102 E. Pikes Peak, Suite 500  
Colorado Springs, CO 80903  
(719) 955-5485

January 15, 2020

**RE: Homestead at Sterling Ranch Filing No.2  
Response to Comment Letter.**

**HOMESTEAD AT STERLING RANCH FILING NO. 2**  
GRADING PLAN  
DATE: 03-03-2020  
PROJECT NO. 09-007  
SCALE: HORIZONTAL: 1"=50' VERTICAL: N/A  
DESIGNED BY: DLM  
DRAWN BY: JWP  
CHECKED BY: VAS

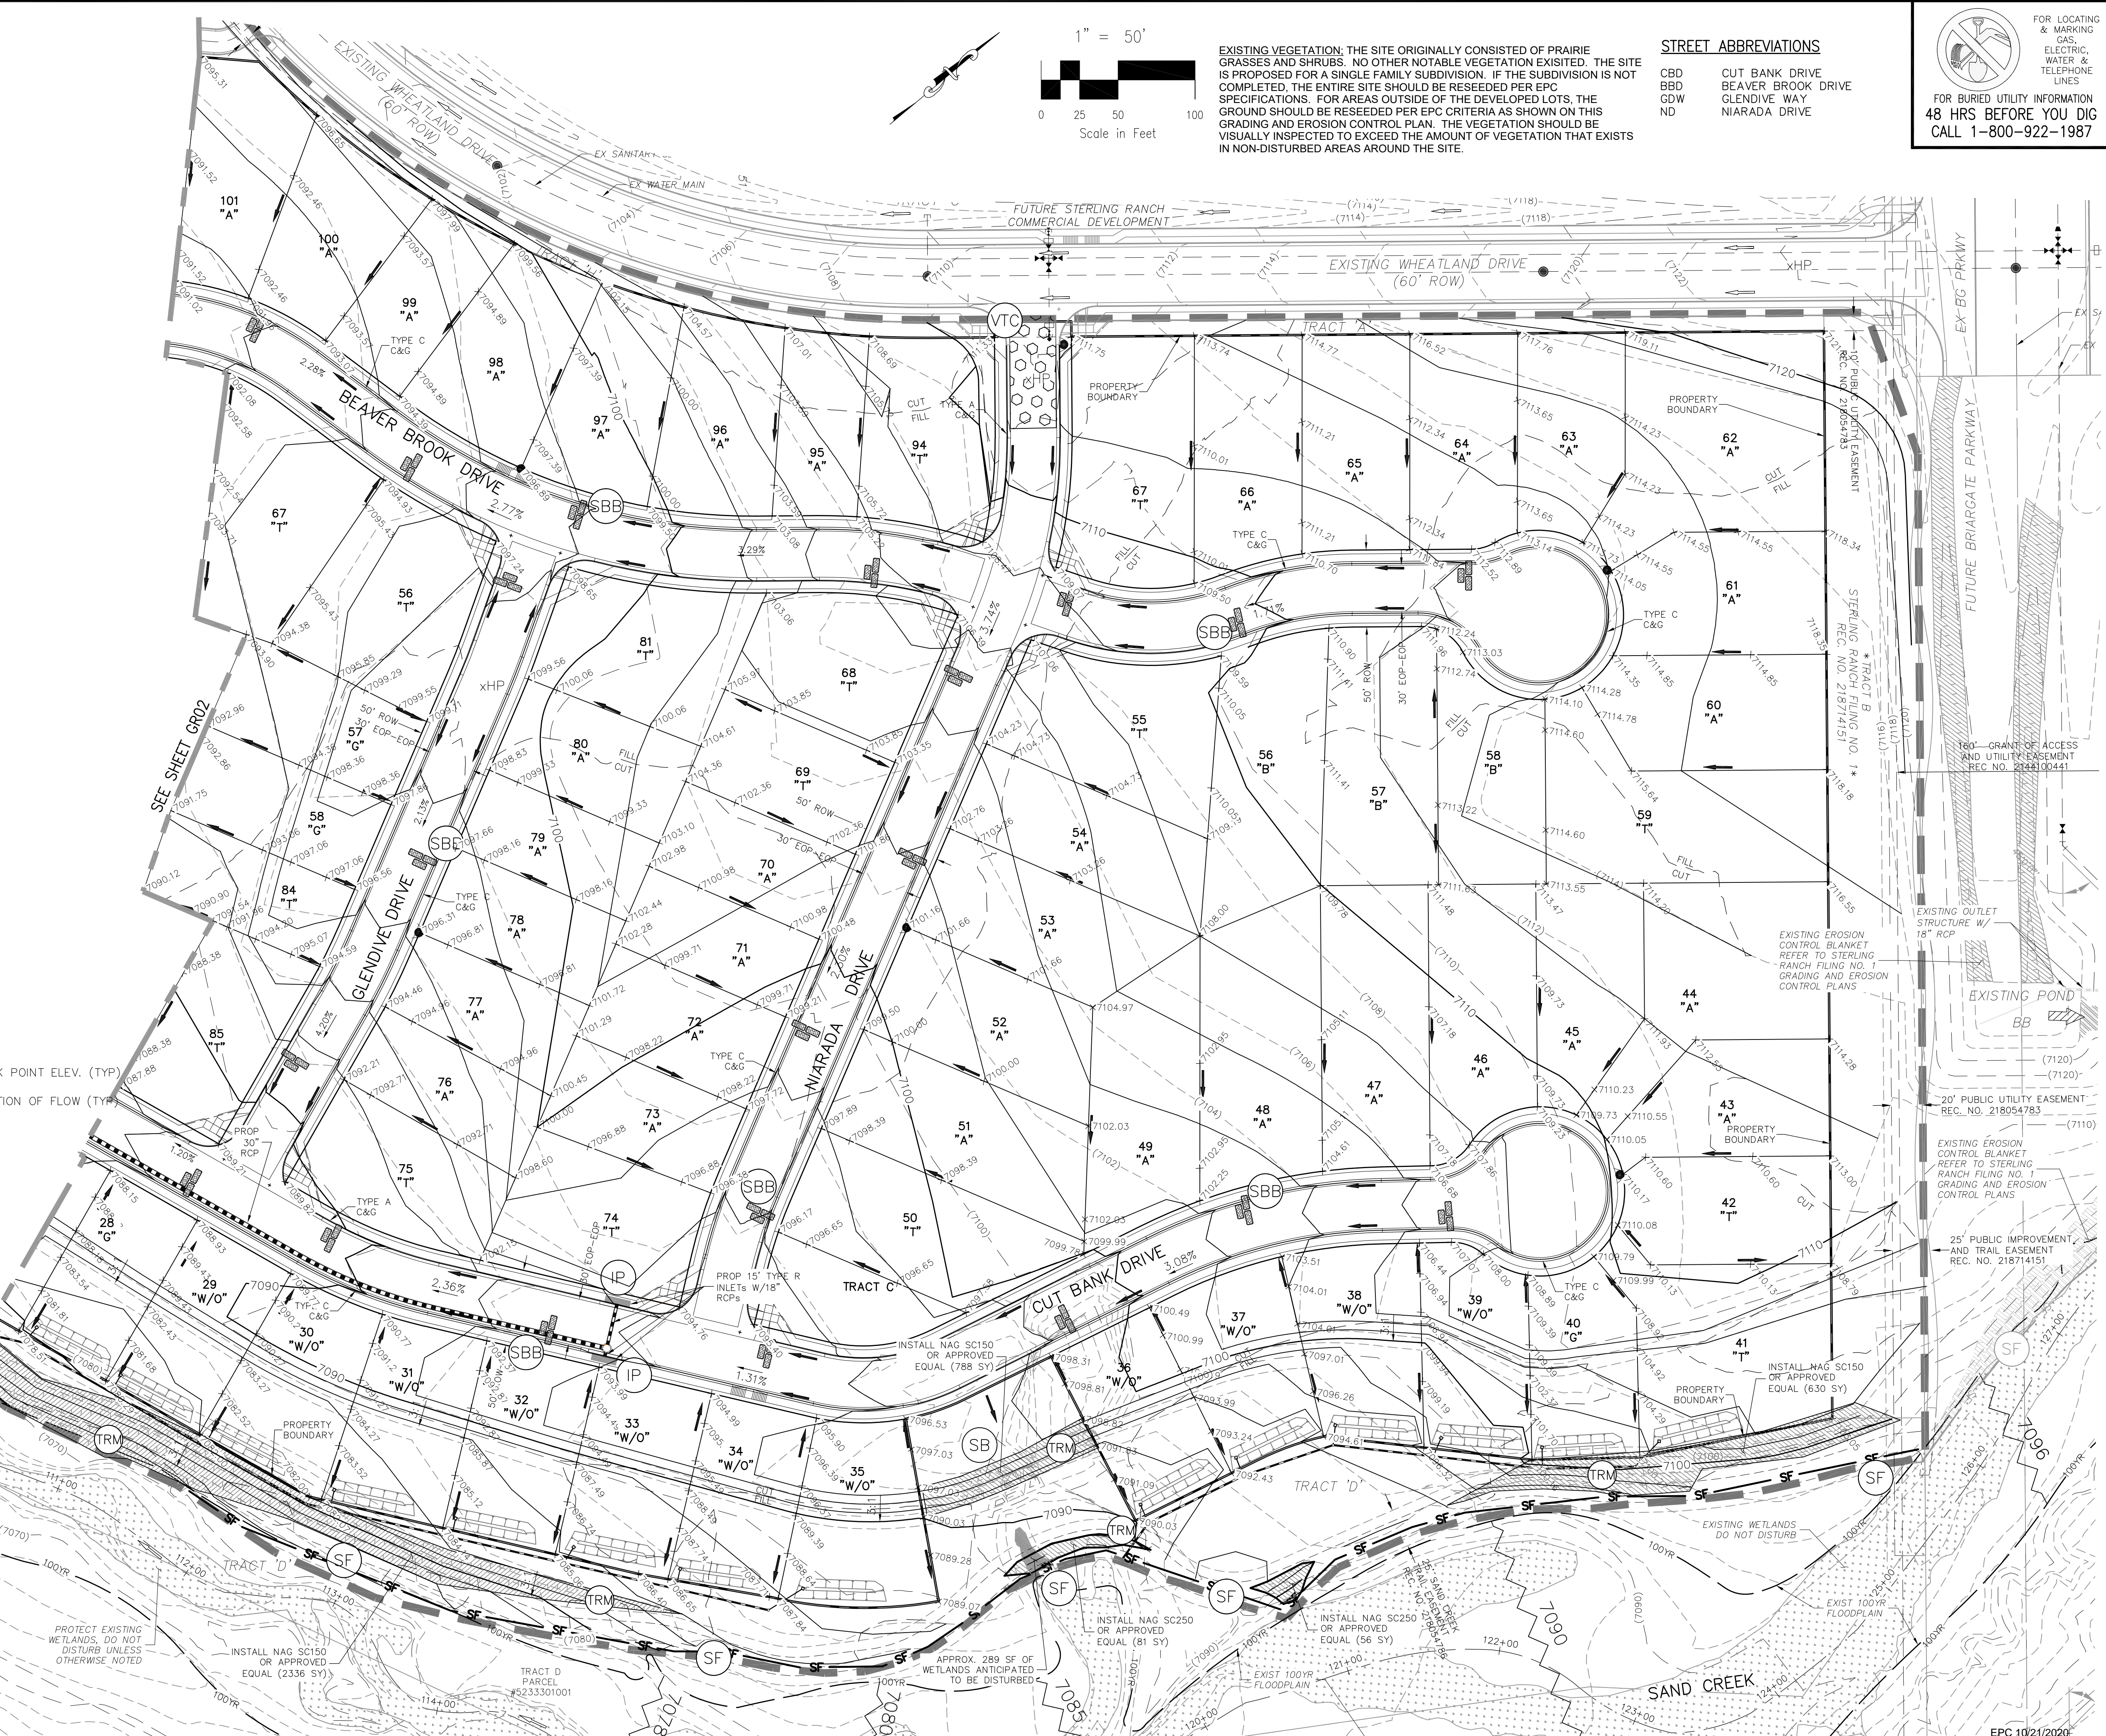
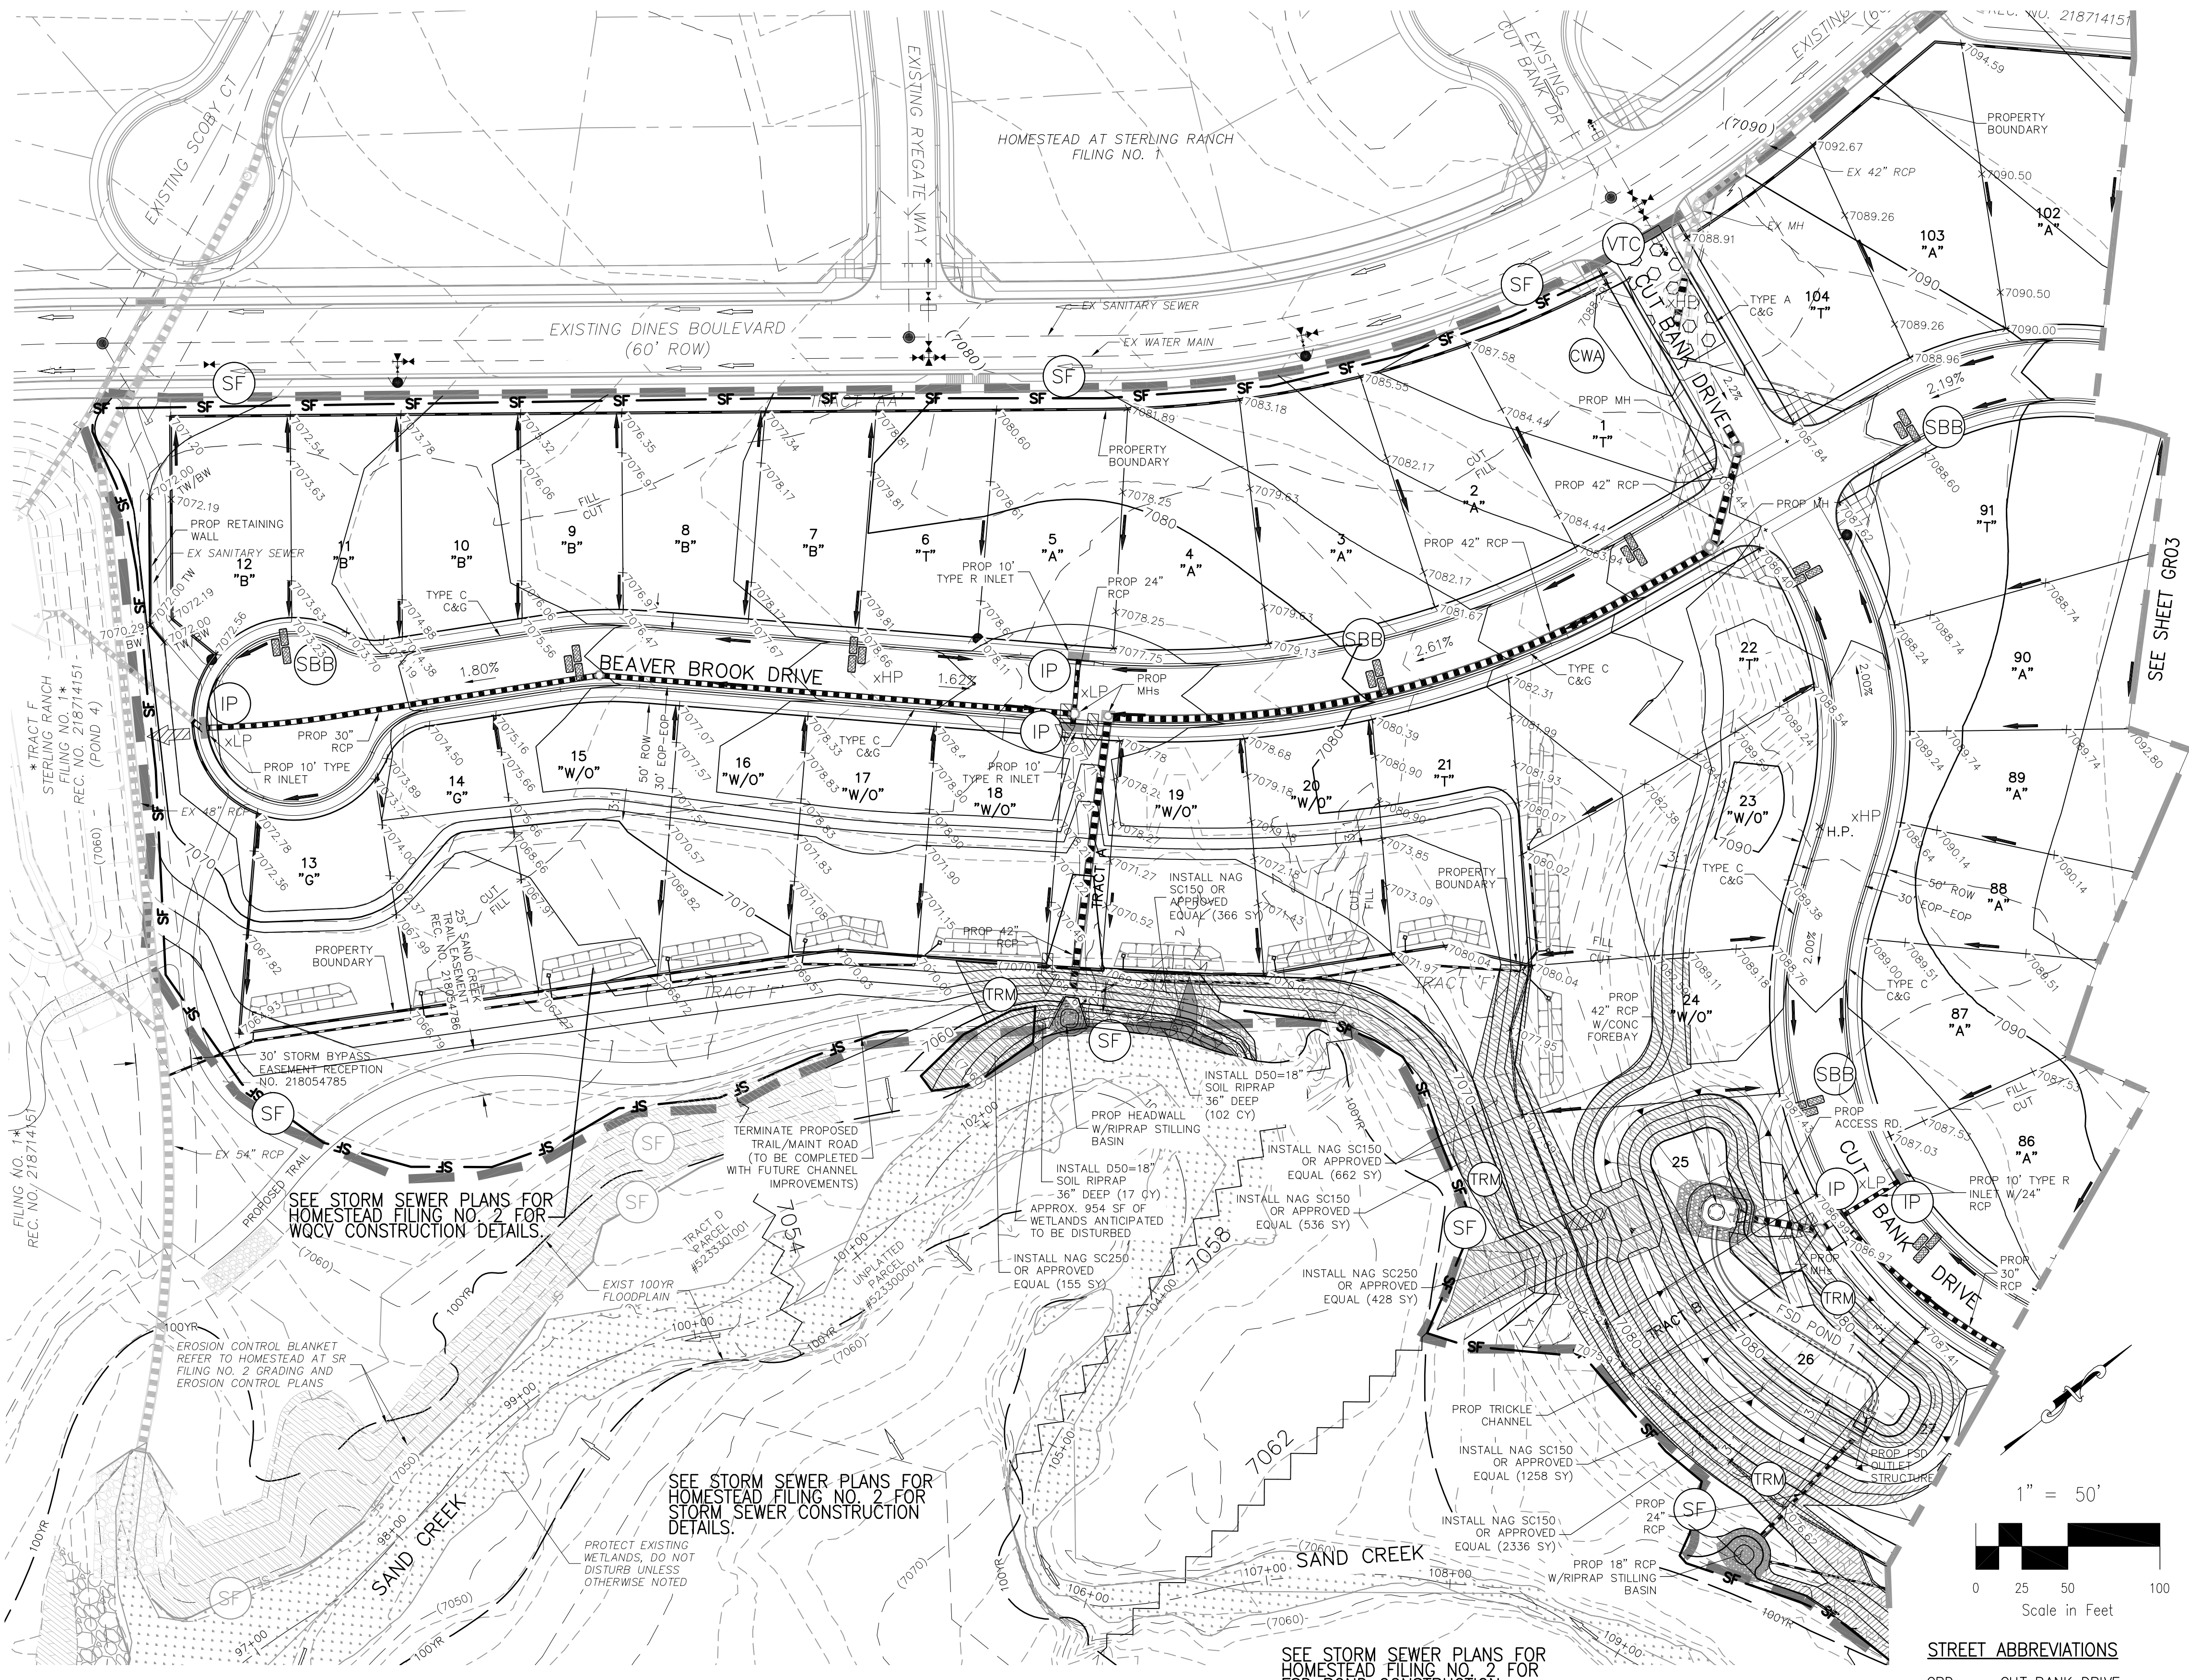
1. **Resolved.**
2. Include more sediment traps and address the scheduling of the two permanent FSD ponds to clarify how sediment will be controlled during construction. **Resolved by added note.**

9. Add the SFBs to the legend.

**Additional sediment traps have been added. The permanent FSD ponds have already been constructed with the approval of the previous 2 or 3 grading plans.**

**SFB's have been added to the legend.**

**CUT BANK DRIVE
 STA 1+54.86 TO STA 14+50.00**

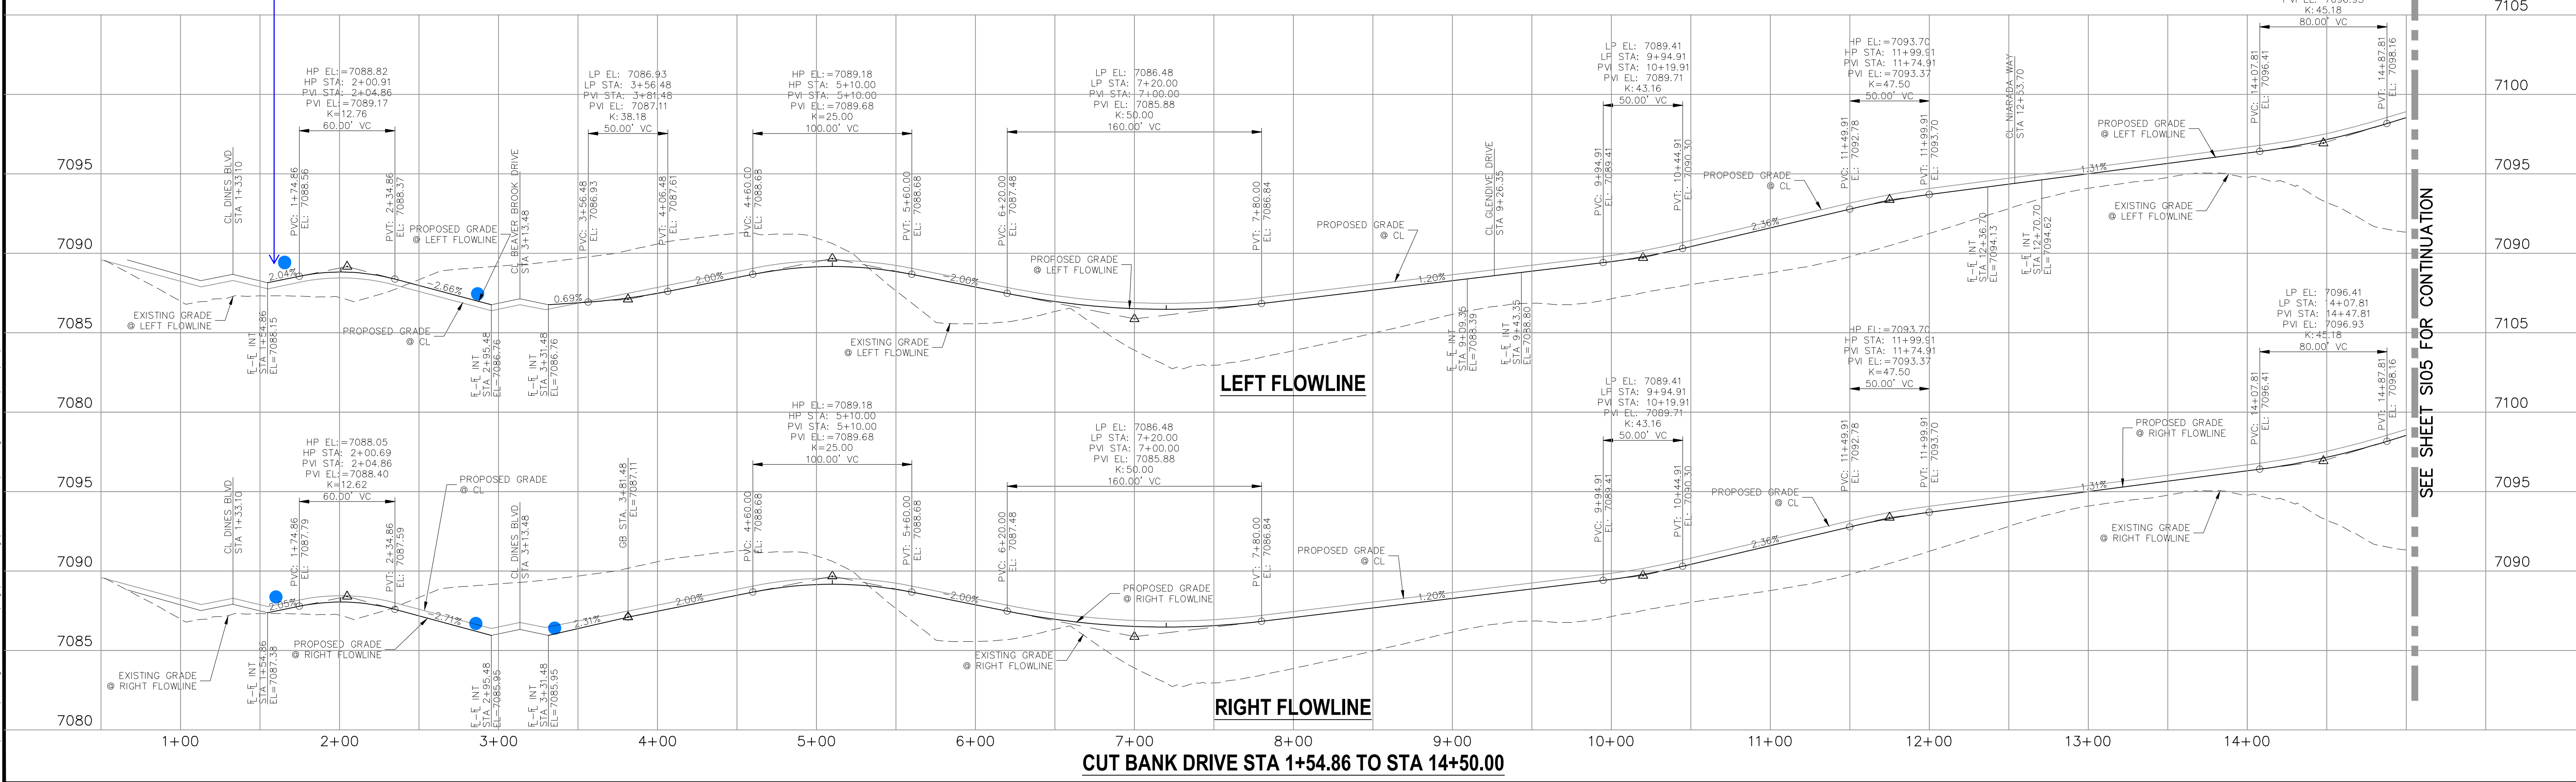
**The posted speed is shown under the typical cross section on sheet 2**
5. Provide detailed intersection grading where accessible pedestrian routes meeting ADA requirements (cross slopes specifically) are required (at stop conditions). Ensure that all pedestrian access routes comply with the requirements compiled in CDOT Design Guide Chapter 12:  
[https://www.codot.gov/business/designsupport/bulletins\\_manuals/design-bulletins/db-2018-4/view](https://www.codot.gov/business/designsupport/bulletins_manuals/design-bulletins/db-2018-4/view)

**The street profiles have been revised to show 2.0% slope transverse to the pedestrian routes. See street profiles.**
6. If there will be USPS mail kiosk/cluster(s) in this subdivision provide location(s) and details.
